### **Submission: SSD-14394209 New Bungendore High School**

Thank you for the opportunity to comment on the amended State Significant Development Application (SSD) for the new Bungendore High School.

## Attachment 1 - Comments on Amended SSDA Proposal – Bungendore High School – August 2024

SC04 LONGITUDINAL SECTION

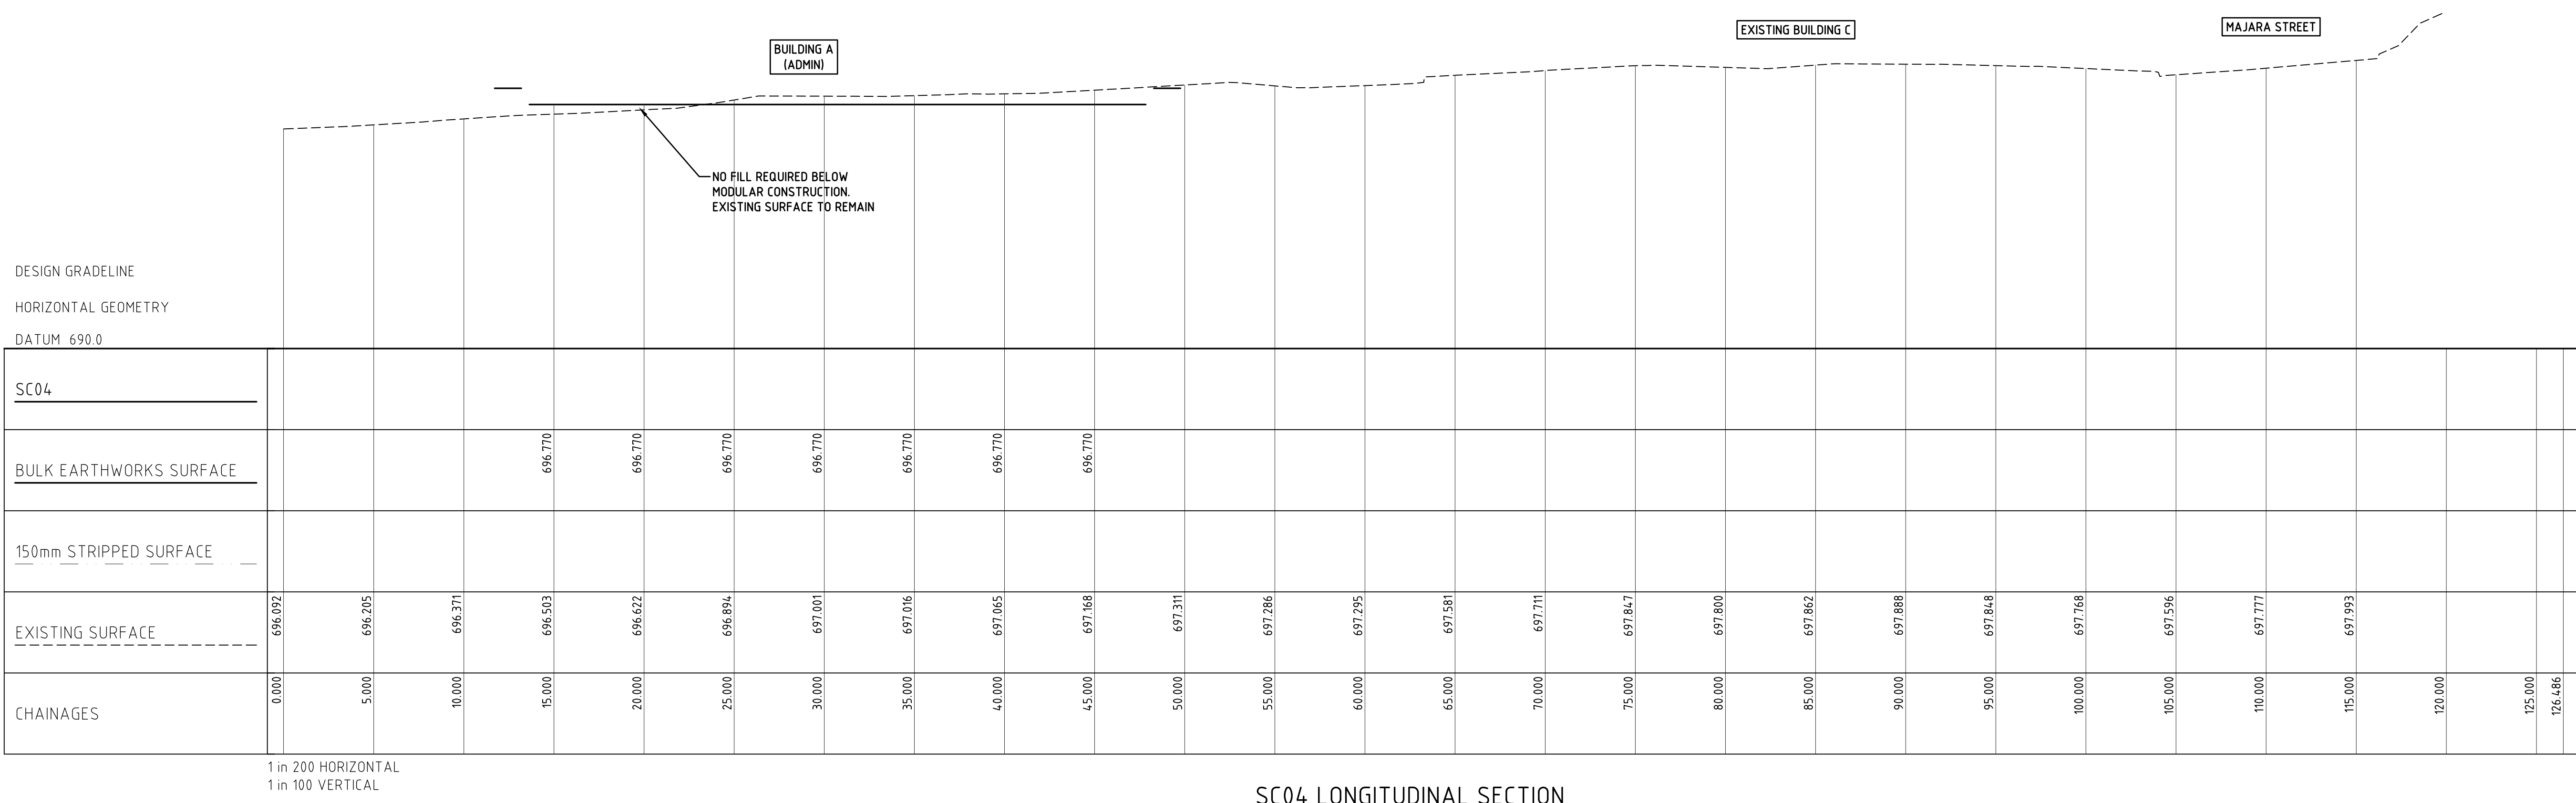
19. Use and Maintenance of Mick Sherd Oval and Games Courts	Further detail required on the cut and fill proposed. In particular Ch 35 on CL SC04 has an existing sewer main crossing the basketball court. Plans show >800mm cut above the main. More effort is needed in the detail design to protect this main and approval from Council's Manager Utilities for any works within the vicinity of the main.	<b>Objection</b> until comments suitably addressed.

21. Other Matters	<p><u>Earthworks</u></p> <p>Further detail required on the cut and fill proposed. In particular Ch 35 on CL SC04 has an existing sewer main crossing the basketball court. Plans show &gt;800mm cut above the main. More effort is needed in the detail design to protect this main and approval from Council's Manager Utilities for any works within the vicinity of the main.</p>	<b>Objection</b> until comments suitably addressed.
